**Application for a non-material amendment following a grant of planning permission.
 Town and Country Planning Act 1990**

DEMOLITION OF EXISTING GARAGE AND ERECTION OF TWO STOREY SIDE AND REAR EXTENSIONS WITH FRONT PORCH.

2022 / 62 / 91811 / W

GROUND FLOOR PLAN

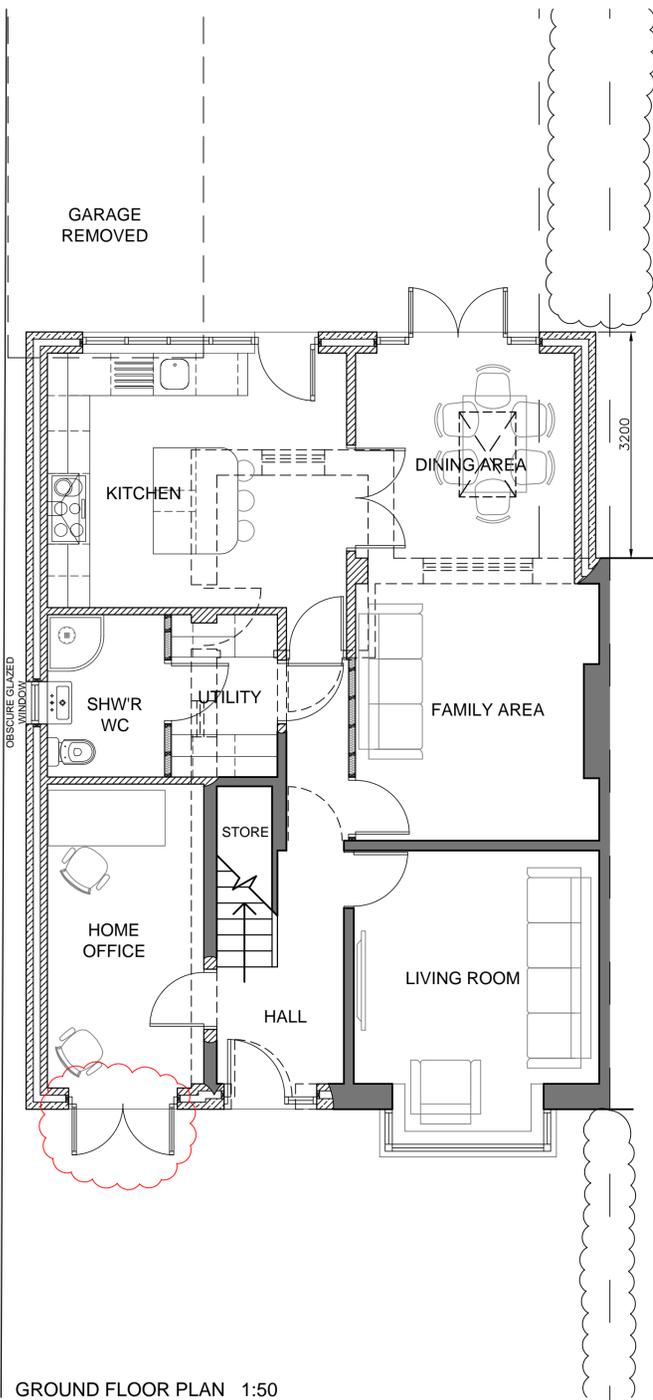
① CHANGE FRONT GROUND FLOOR WINDOW TO PATIO DOORS.

FRONT ELEVATION

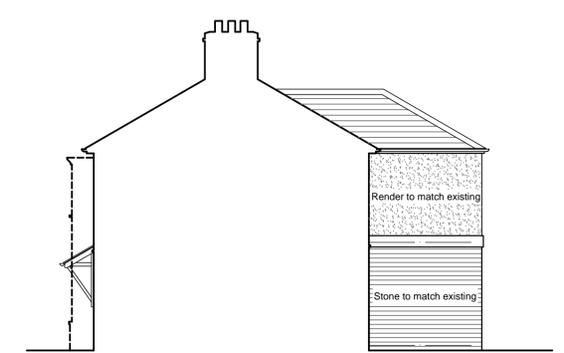
ALLOW BETTER USE OF THE HOME OFFICE
